REVIEW COMMENTS

Project:		NM 335.01 Gibson & 98th St Gas Station		PDE:		
Review:				Reviewer:		
Date:		12/12/2022		Matt Grush, P.E.		
#	PAGE	SECTION	COMMENT	AGENCY	STATUS	RESPONSE
1	2	Introduction (Figure 1)	Locate Driveway B as far east as practicable. This will improve the access to the westbound leftturn lane at 98 th St and provide space for future lengthening of the right-turn lane.	COA	Agree	Accepted see new site plan included as Figure 1
2	2	Introduction	Relocate Driveway A to the north limits of the development	COA	Evaluate	The location of driveway A is fixed as an existing access point. This access point is an existing access easement.
3	48	Development Site-Specific Observations and recommendations	Add a right-turn lane [Driveway A], the length may be less than the DPM requirement. The City may accept a reduced length of the turn lane. Provide a short discussion on the effectiveness of the modified turn lane.	COA	Agree	A right-in / right-out driveway with a right-turn deceleration lane has been added to the site plan located south of driveway A. A discussion of the deceleration's effectiveness has been added to the body of the report.

SHEET NO.
T02.0

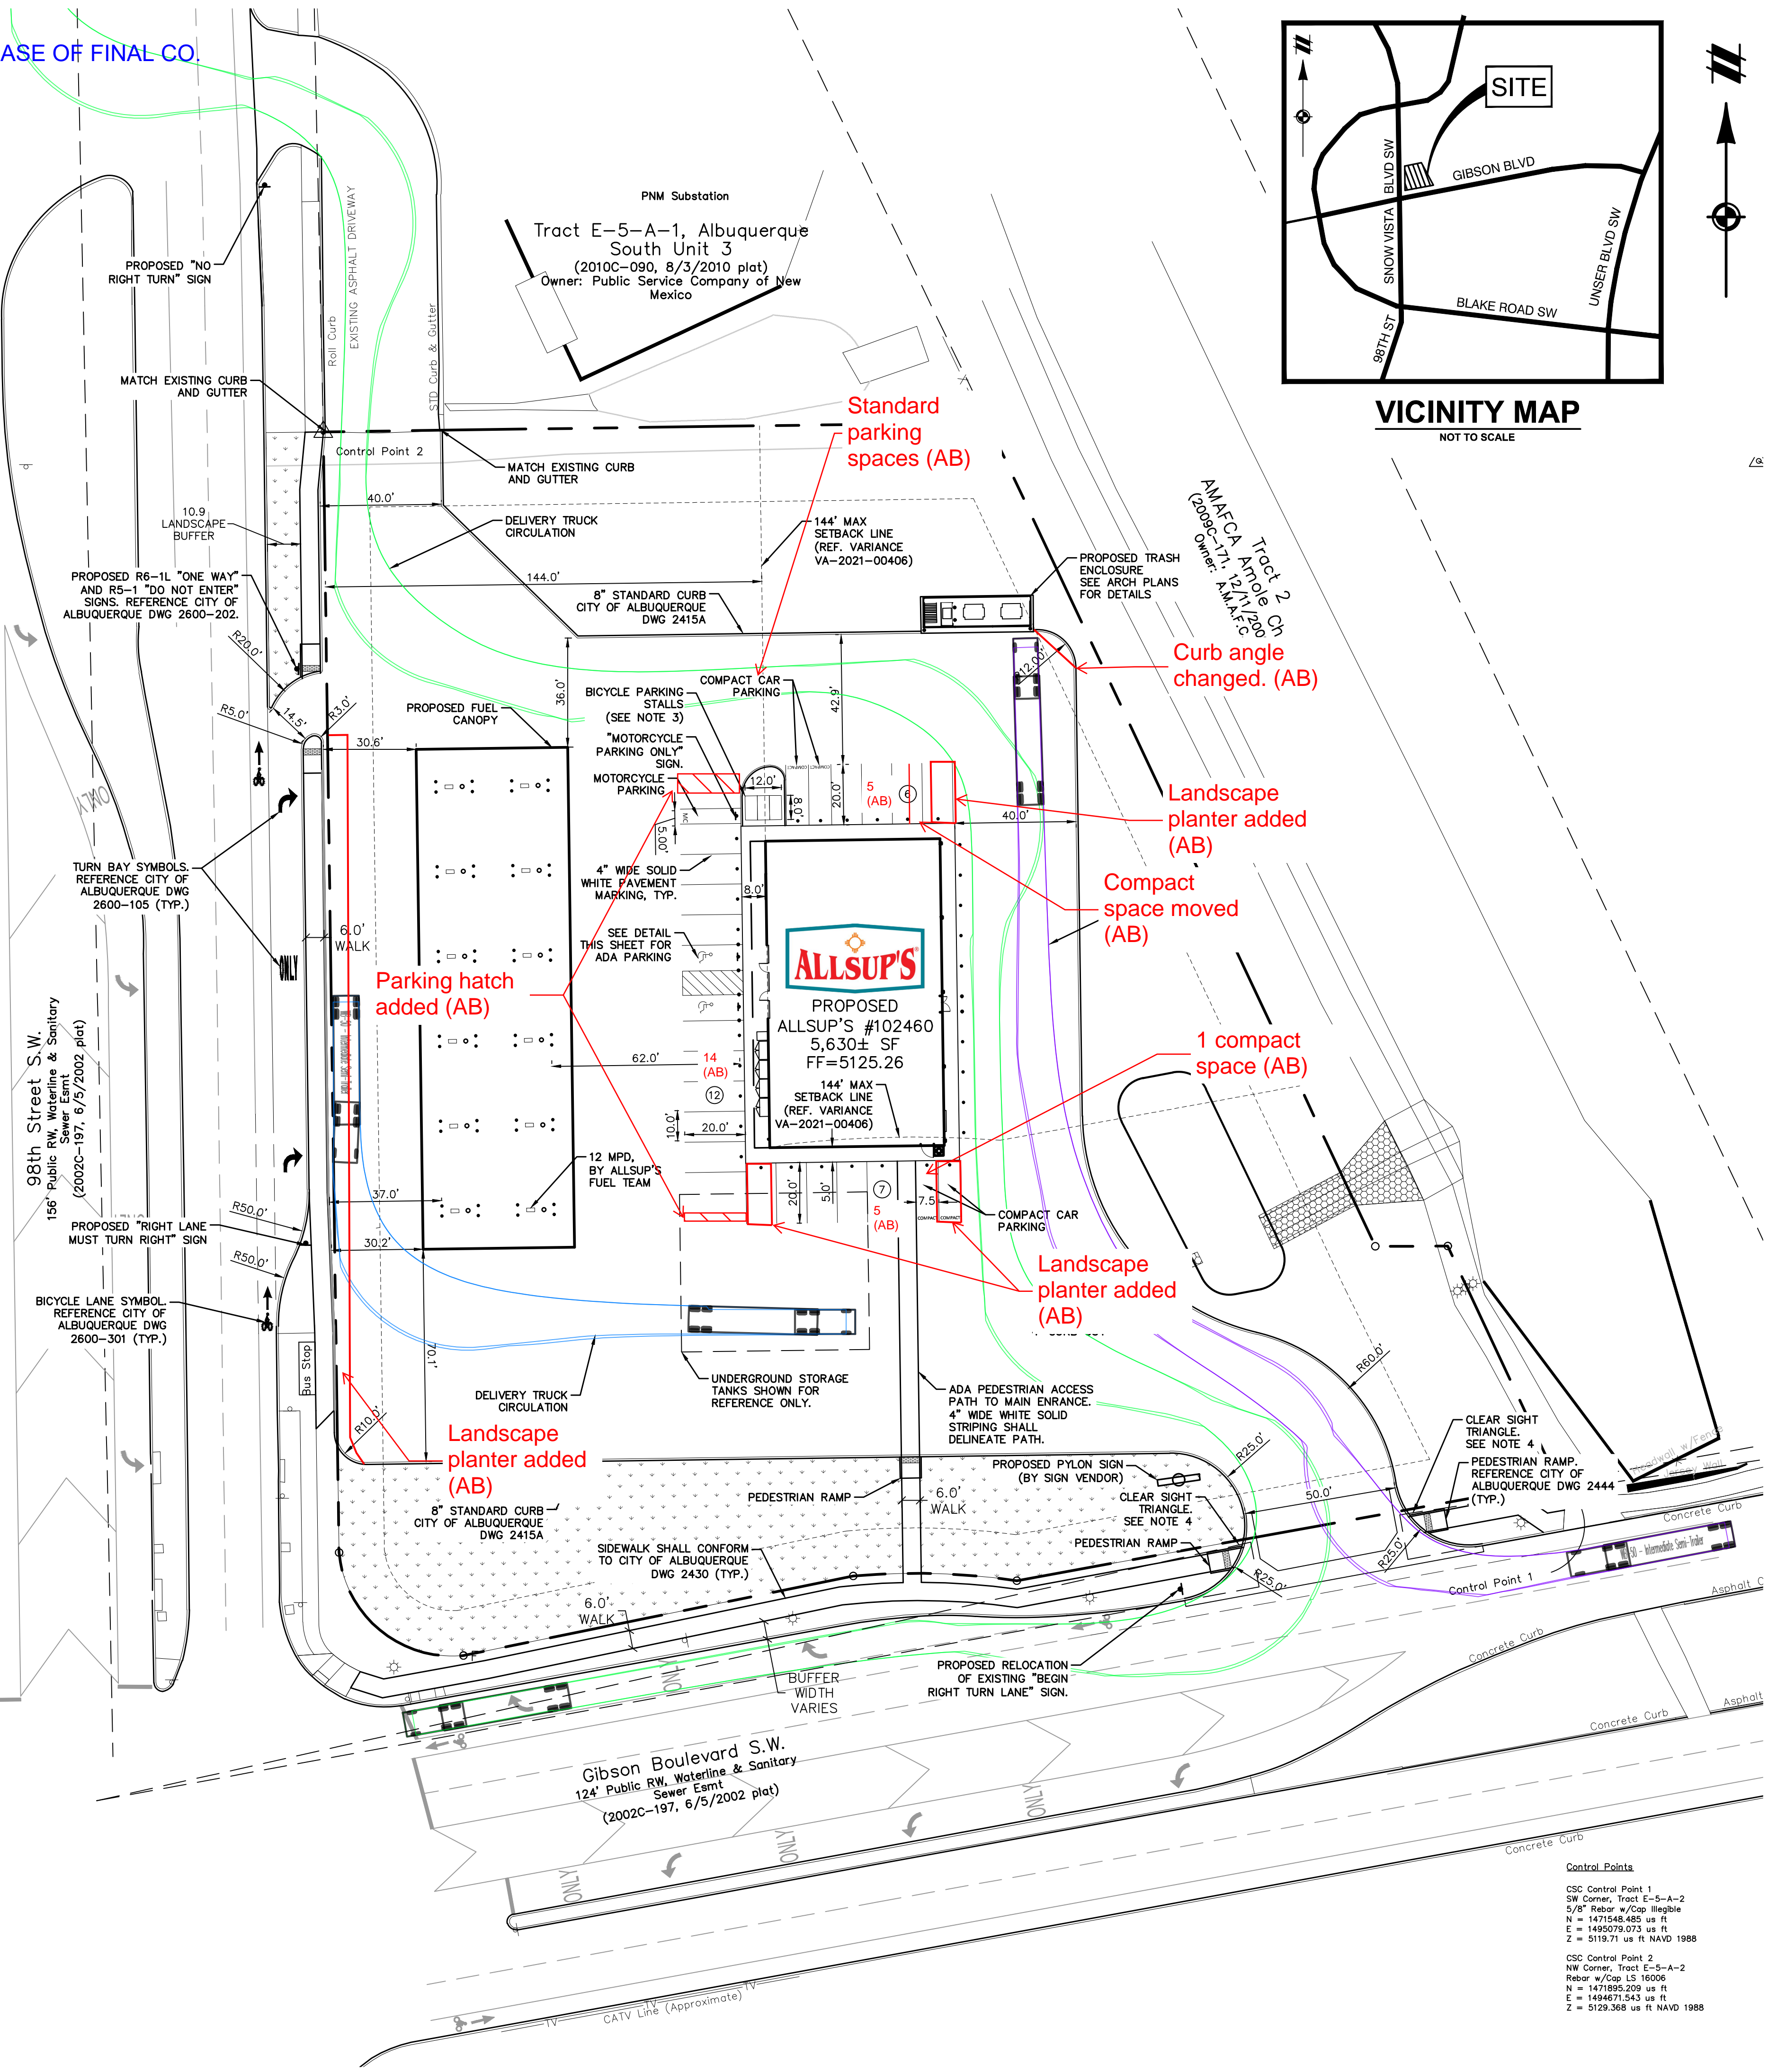
4	2	Introduction (Figure 1)	The transit stop should remain as is. The northbound right-turn lane can begin immediately north of the transit shelter.	COA	Agree	Accepted: This configuration is reflected in the newest site plan included as Figure 1
5	2	Introduction, Development Site-Specific Observations and recommendations	The access to the PNM facility should remain. Add a notification sign that this driveway is for PNM access only/dead end or what you feel is needed to discourage erroneous use of this driveway. The developer should coordinate with PNM concerning this driveway.	COA	Agree	No-Right turn sign added to driveway.
6	3	Summary of Recommendations	Summary of recommendations on page 3 describes Driveway A as right-in only. The analysis has this as a partial right-in/right-out. Please correct this to be a partial right-in/right-out access	COA	Evaluate	The summary of recommendations describes Driveway A as a Full Access driveway. The developer has since added a driveway to function as a right-in / right-out south of Driveway A on 98th St. This configuration change would make Driveway A a Left-in/ Left-out access point. Signing for both Driveway A and the new right-in/right-out driveway just south of it is shown in the new site plan shown in Figure 1.
